## DECISION DELEGATED TO DEVELOPMENT MANAGER

| <b>Application No:</b> | <b>H09-1169-19</b>                                                                                                                                                                                                                                                                                                                            | <b>Applicant:</b> | <b>Mr J Russell</b> |
| <b>Proposal:</b>       | Proposed erection of a purpose-built 20 kennel unit to house 20 adult dogs and retrospective planning permission for the siting of an existing outbuilding (approved under H09-0548-16) 65.81 metres from the road, retention of outbuilding for sheep food & straw storage, and change of use of proposed site from agricultural to domestic |                   |                     |
| <b>Location:</b>       | Duntreath Cackle Hill Lane Holbeach

AMENDMENT - BLOCK PLAN 1:500

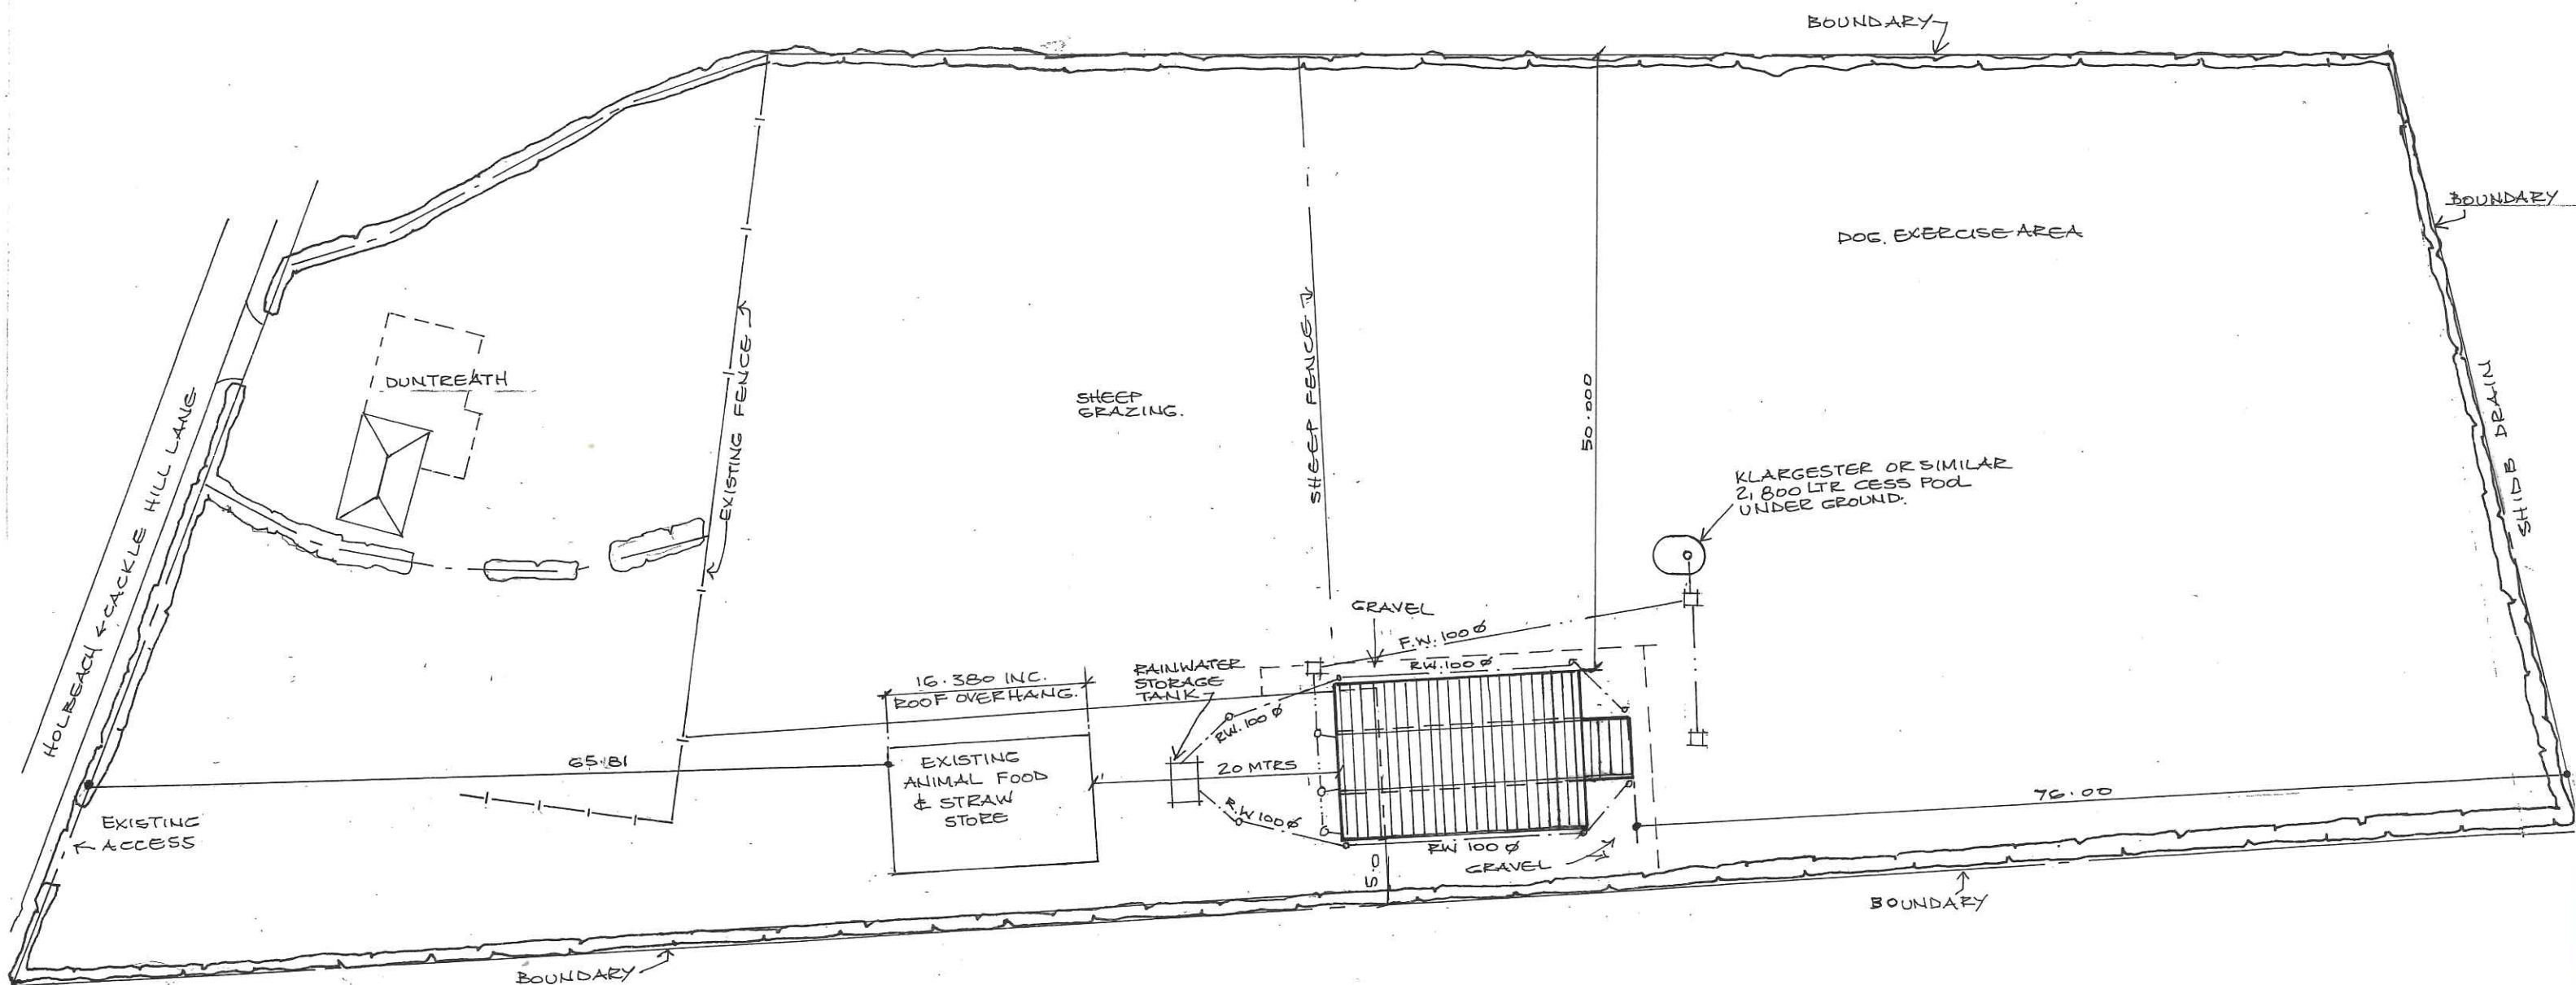
- *Position of existing outbuilding:* Permission was granted for a proposed agricultural building under application H09-0548-16. The approved block plan shows the footprint of such building 40.3 metres set back from the road. However, aerial views demonstrate that the building has been built approximately 65 metres from the road.

- *Use of existing outbuilding:* Permission was granted for agricultural purposes under application H09-0548-16. To regularise its use so far and prevent any enforcement action in the future, the last revised plans show sheep food & straw storage which would fully comply with the agricultural use previously permitted.

In terms of the existing building granted permission for agricultural purposes under H09-0548-16, which has been built further from the road than approved (65.81 metres away rather than 40.3 metres), this is arguably an improvement as the building is now located further in the site. Thus it is further away from the access point and views into the site than it would otherwise have been.

With regard to the land for which retrospective permission is sought for domestic use, this is indicated on the block plan. It is not considered that the change of use of this area of land from agricultural to residential has resulted in a material adverse impact on the character and appearance of the area.

PROPOSED REAR ELEVATION 1:100

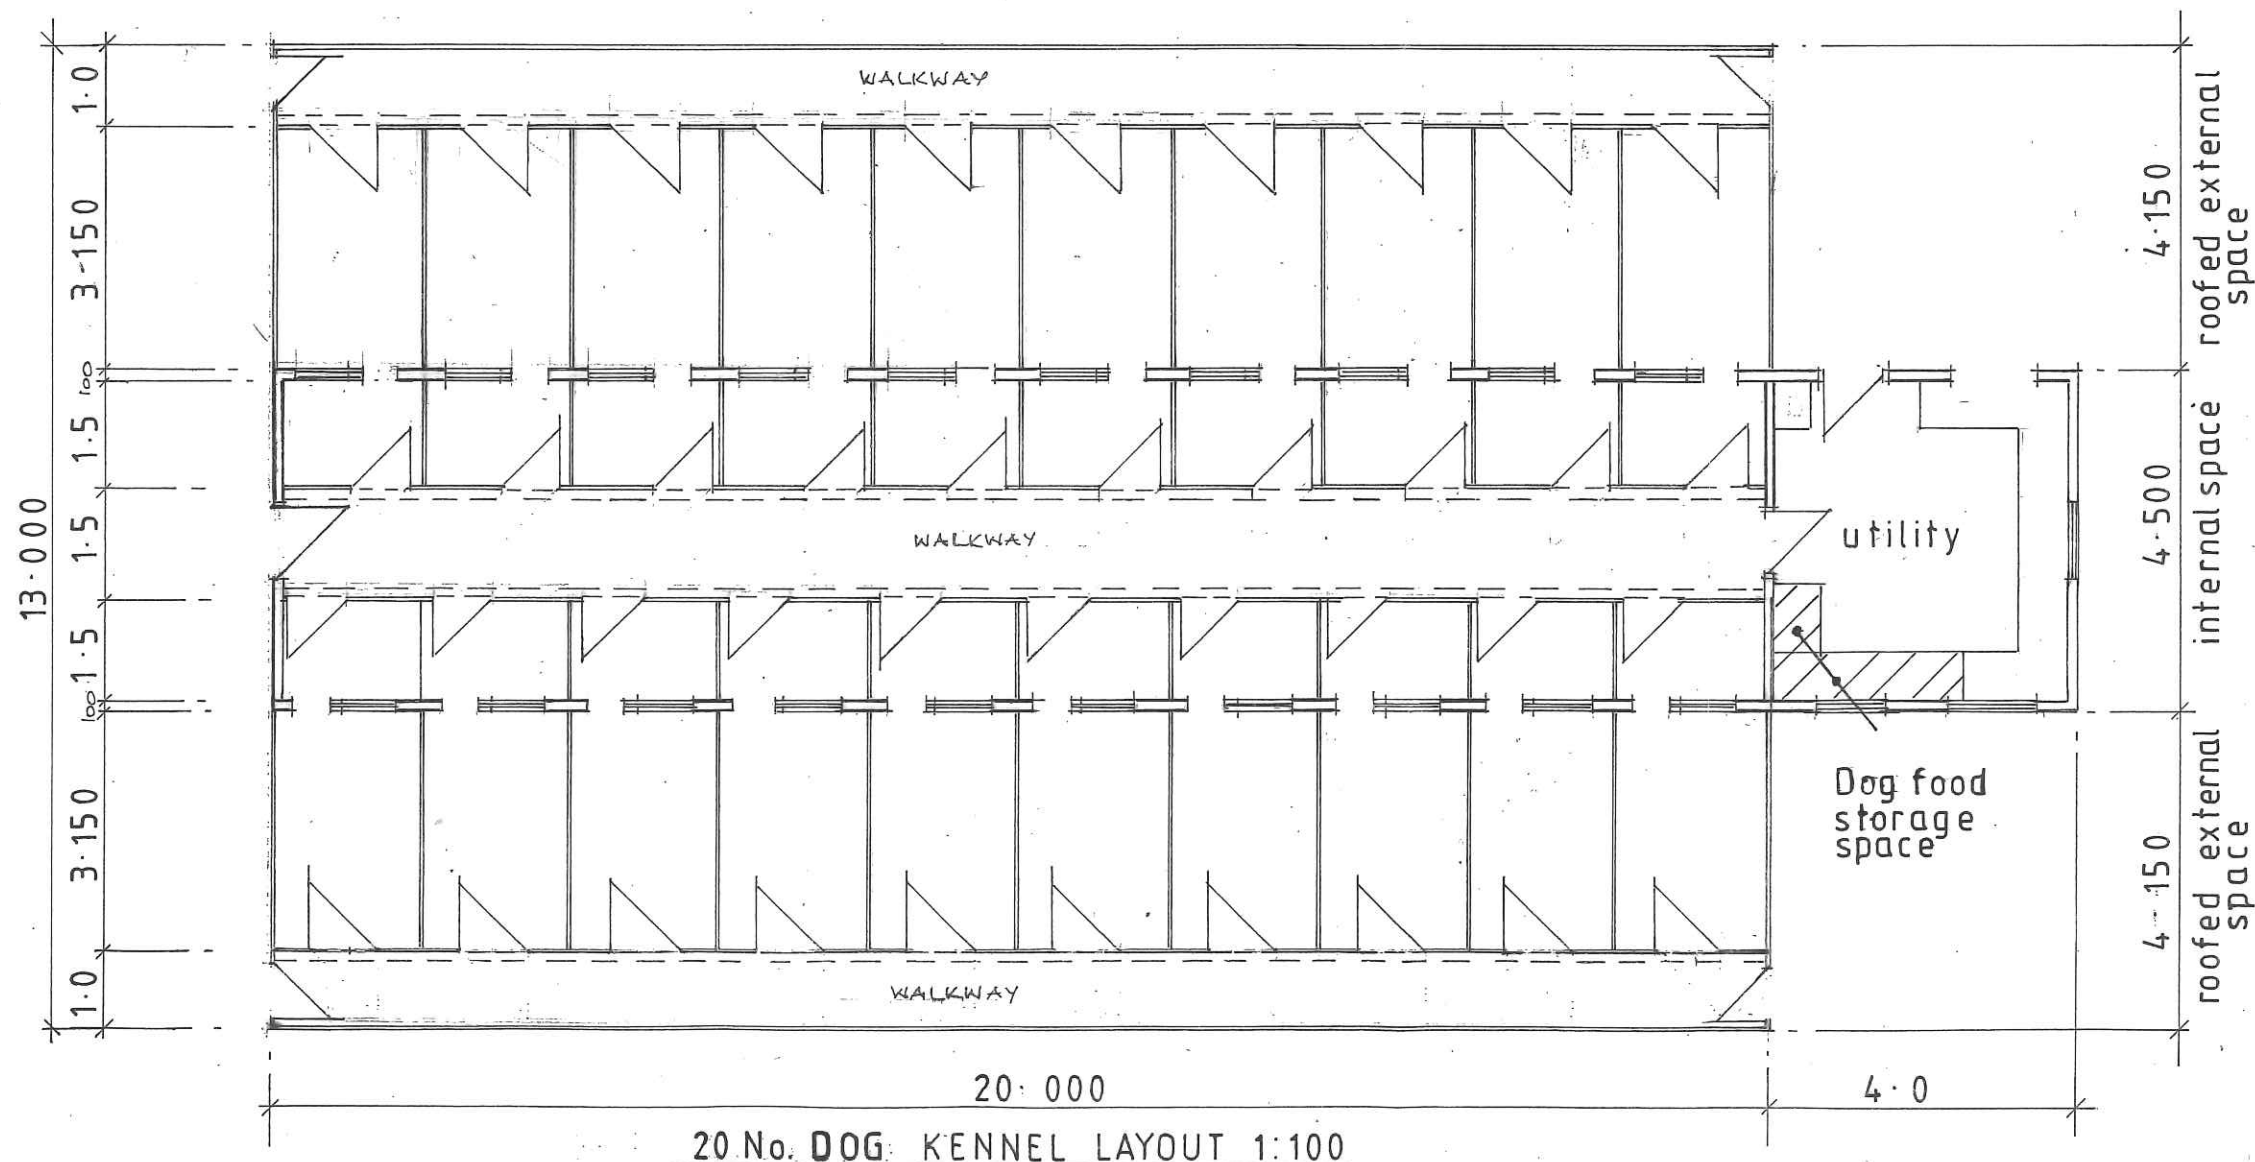
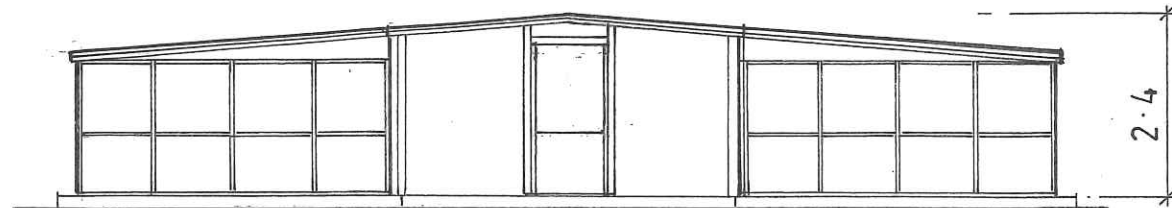
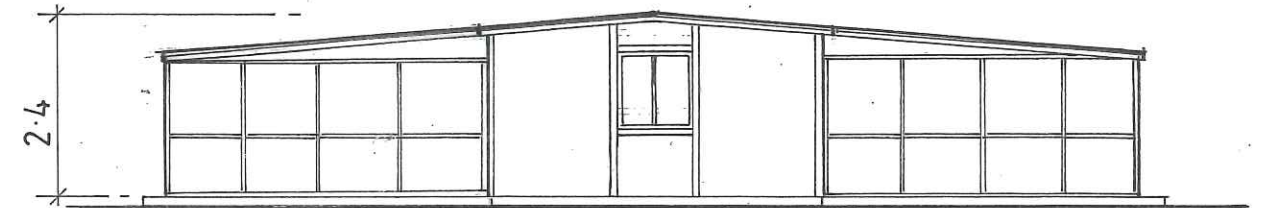
The proposed kennels would be 20 metres in depth and 13 metres in width. The ridge height would be 2.4 metres and the eaves would be 1.9 metres, hence the roof pitch would be low. The structure would be erected on top of a hardstanding base which would raise marginally the entire outbuilding from the ground level. Having regard to the scale of the site and the screening provided by the existing boundary treatment, it is not considered that the kennels would be inappropriate in terms of scale or its impact on the wider landscape.

White Trapezoidal roof panels (KS1000 RW by Kingspan) are proposed for the walls and roof of the proposed kennels. The form and appearance of the development would be characteristic of agricultural buildings for storage which are widely present across the countryside of the district.
